CHENNAI METROPOLITAN DEVELOPMENT AUTHORITY
Thalamuthu Natarajan Building, No.1, Gandhi Irwin Road, Egmore,
Chennai - 600 008
Phone : 28414855 Fax: 91-044-28548416
E-mail: mscmda@tn.gov.in
Web site: www.cmdachennai.gov.in

Letter No.C3 (N)/10532/2016 dated: 15.12.2016

Sub: CMDA – Area Plans Unit – MSB (North) Division – Planning Permission Application for the proposed construction of Group Development of Multi-storied Buildings Main Block with Basement floor + Ground floor + 5 floors Hospital Building, Temple with Ground Floor only and Stack parking 4 nos with 6 levels, at Pillaiyar koil strret, Thirumangalam, Chennai - 40. Old S.No.230/7A pt, T.S. No. 8, Block No. 27 of Koyambedu Village. Within the limits of Chennai Corporation – Particulars requested – Reg.

THIRD AND FOURTH FLOOR PLAN

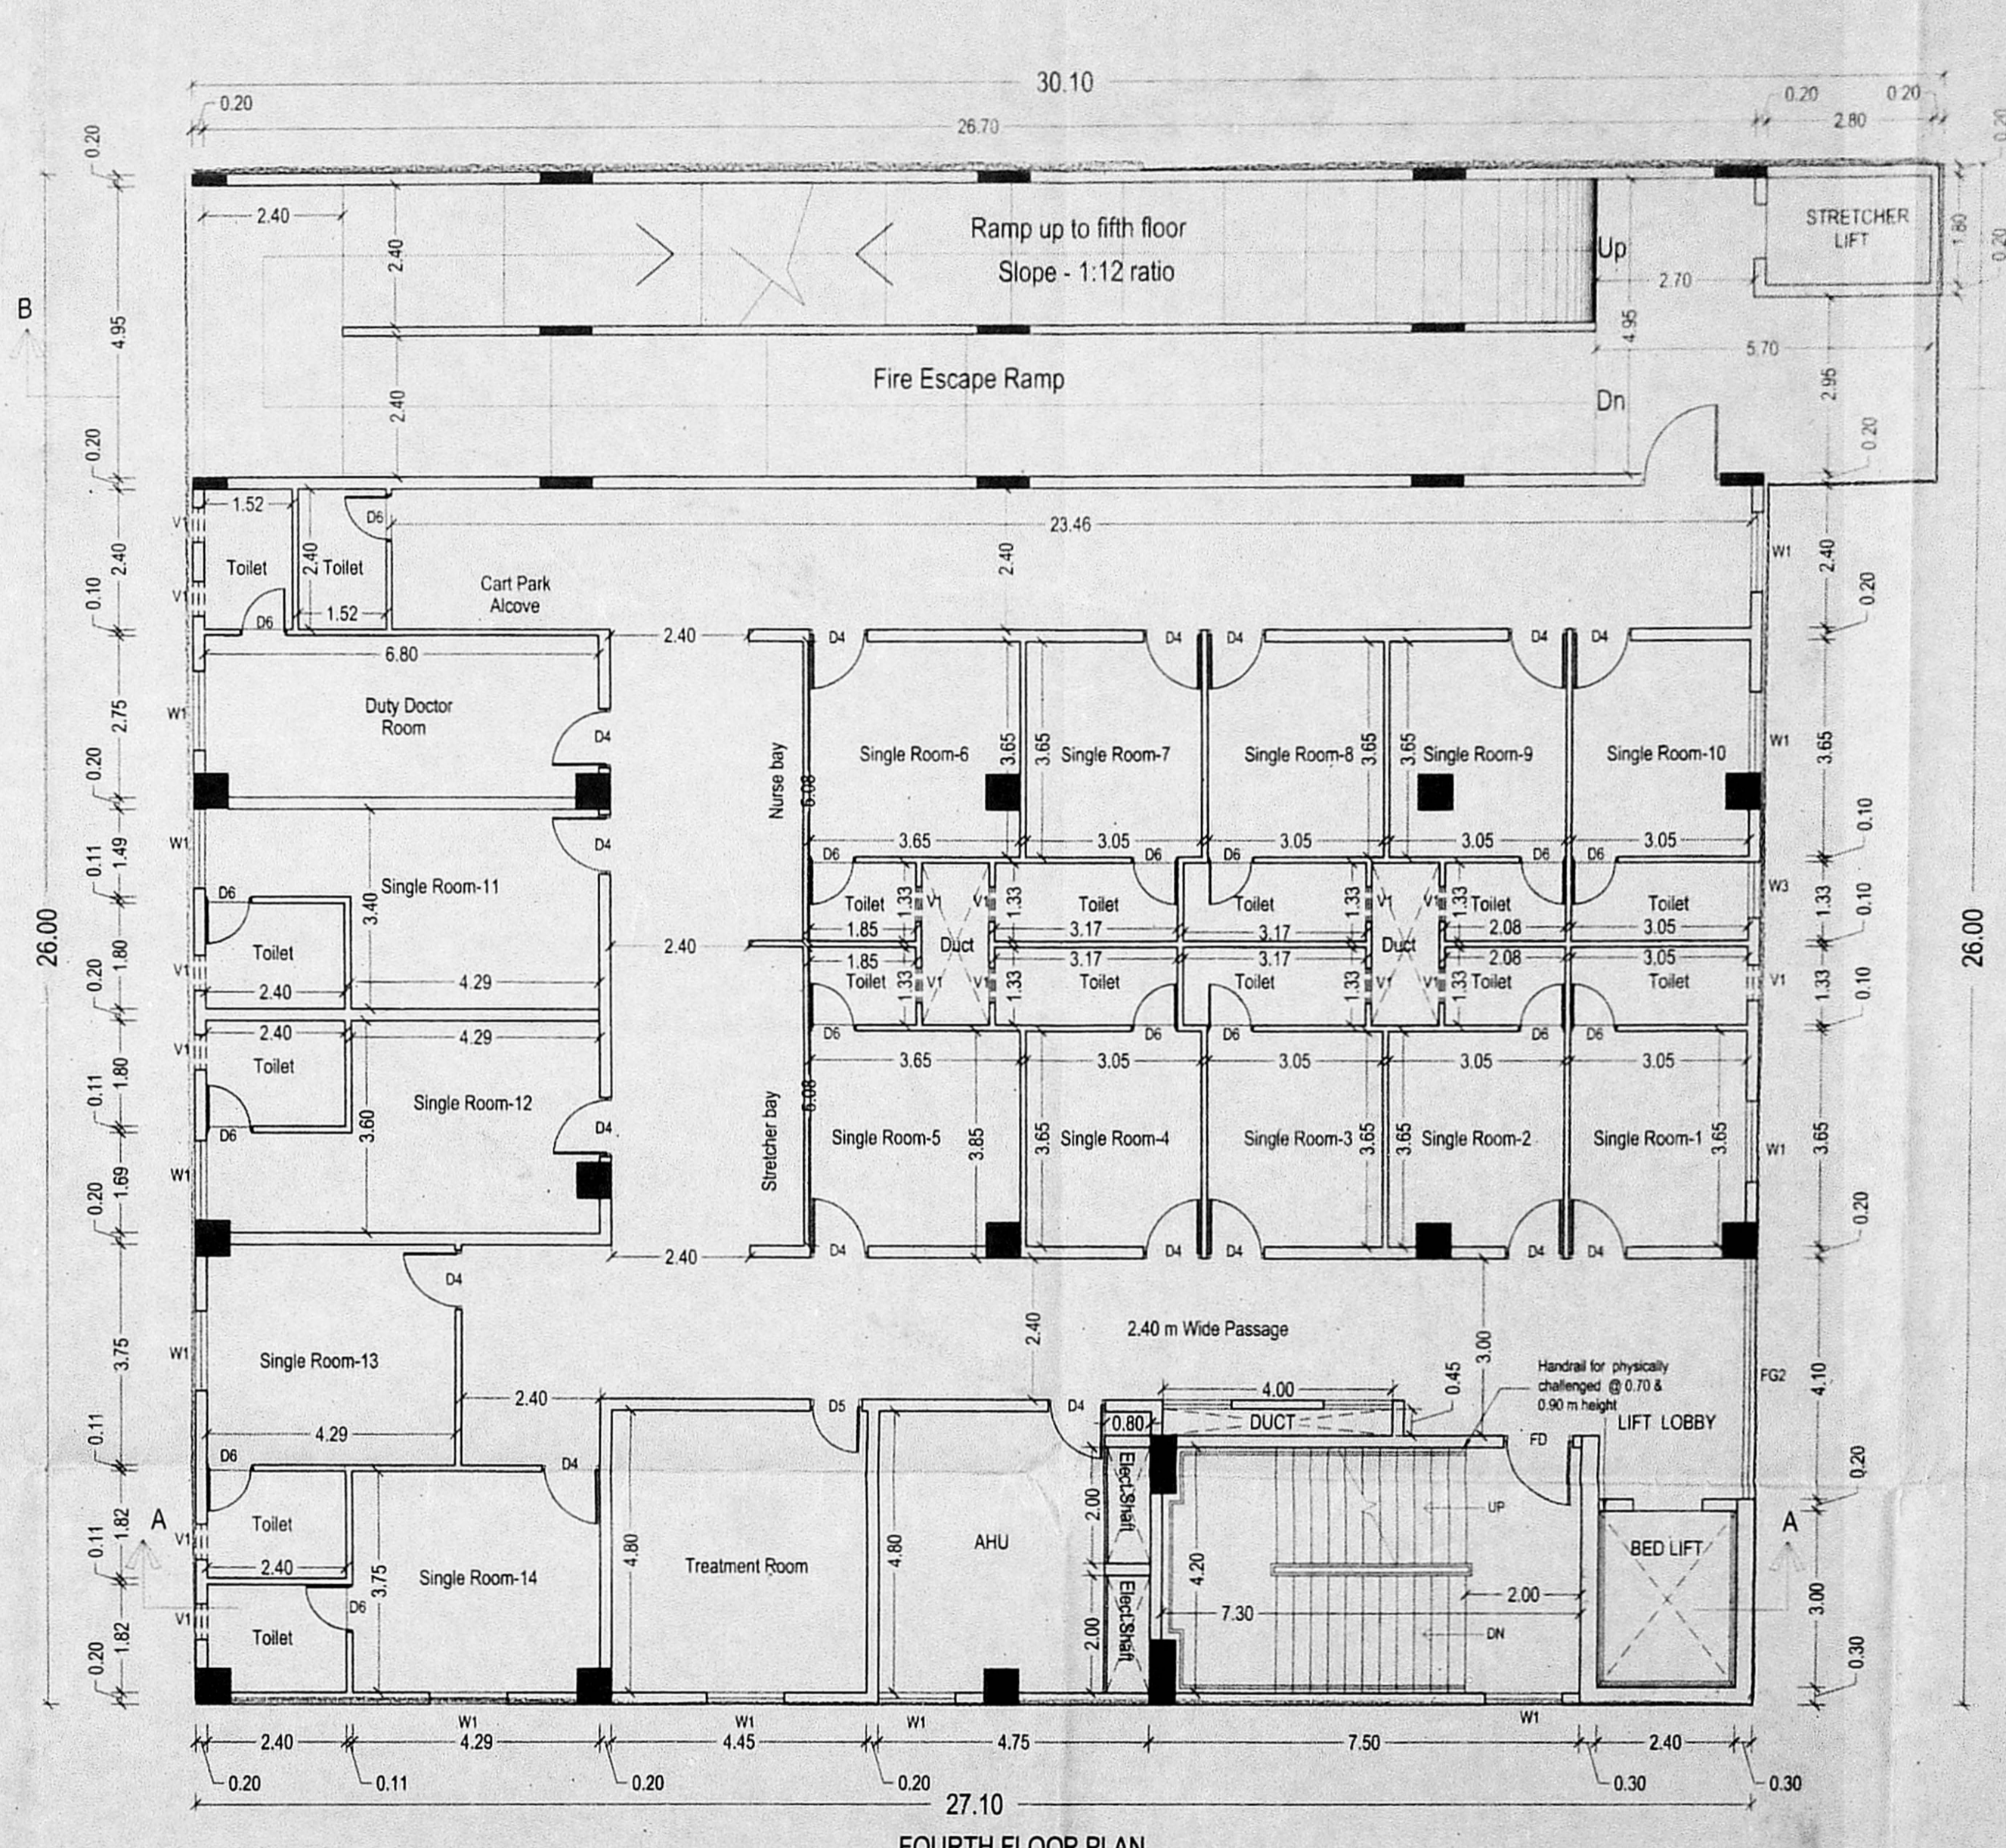
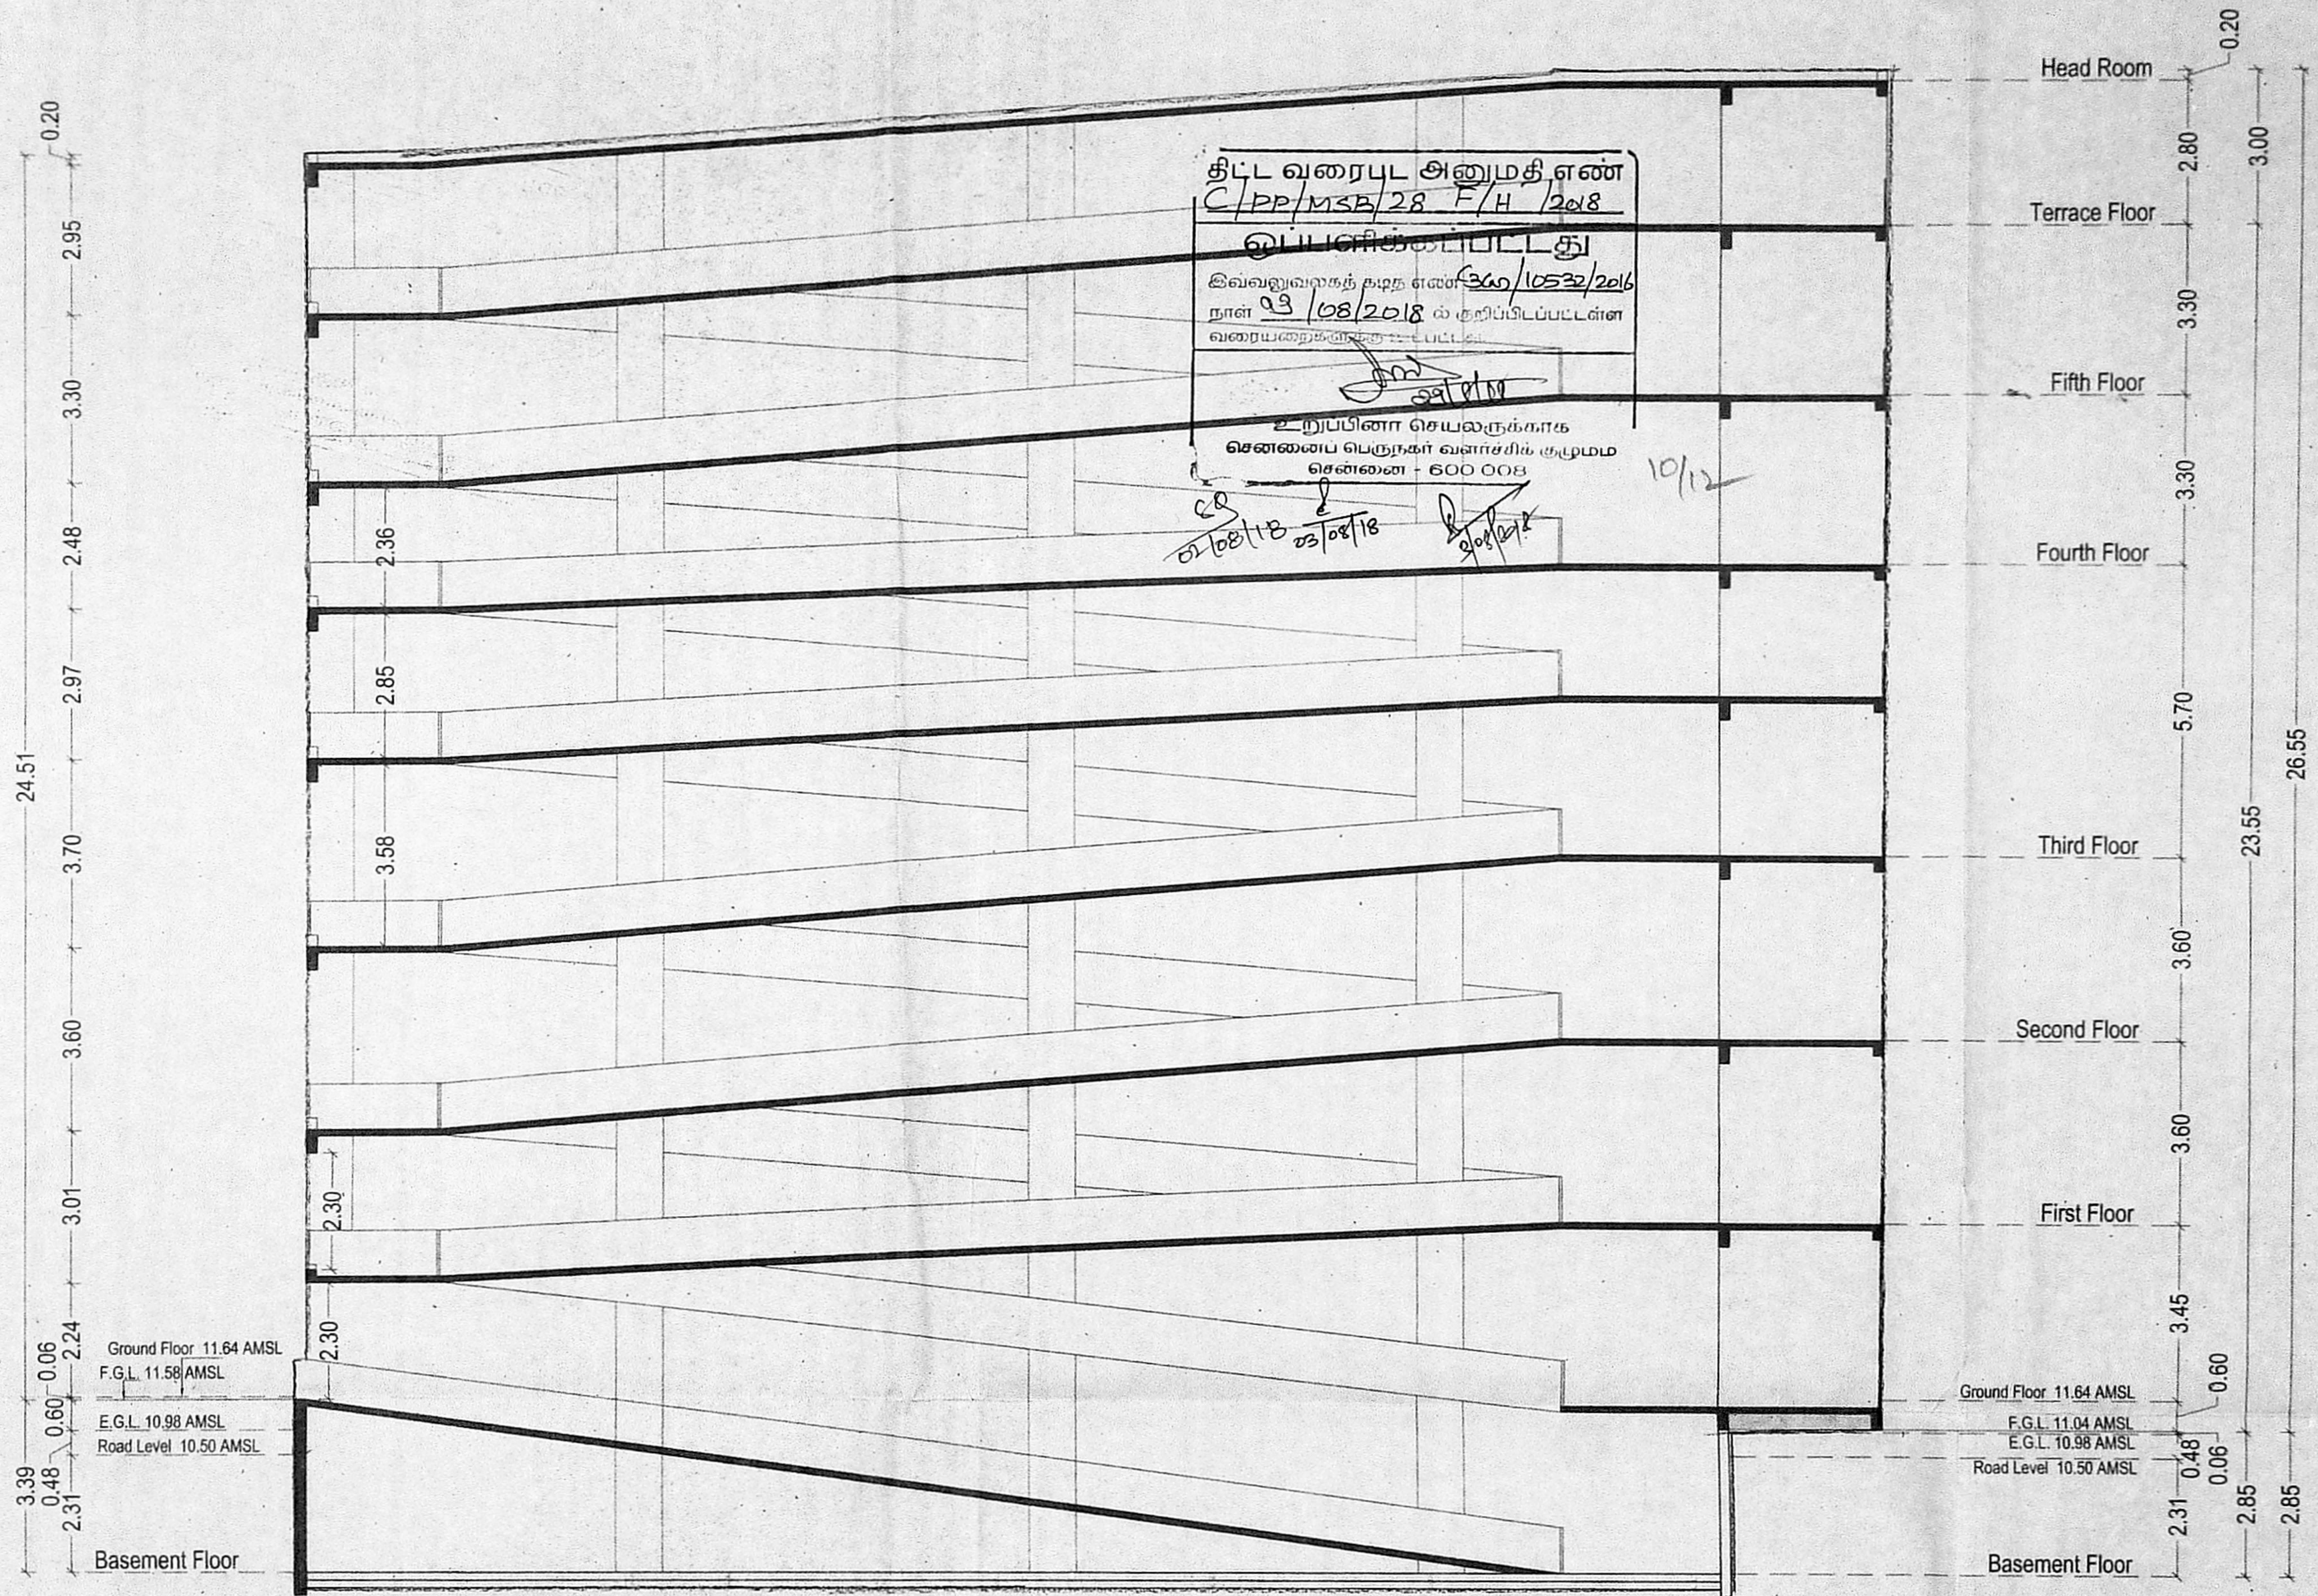
1. Width of ramp 2.40 m and length satisfying 1:12 slope in all floors to be provided and to be specified as fire escape ramp in all floors and entrance landing width to be shown as 2.40 m in all floor plans and car parking is Less by 7 nos as per DR requirements.
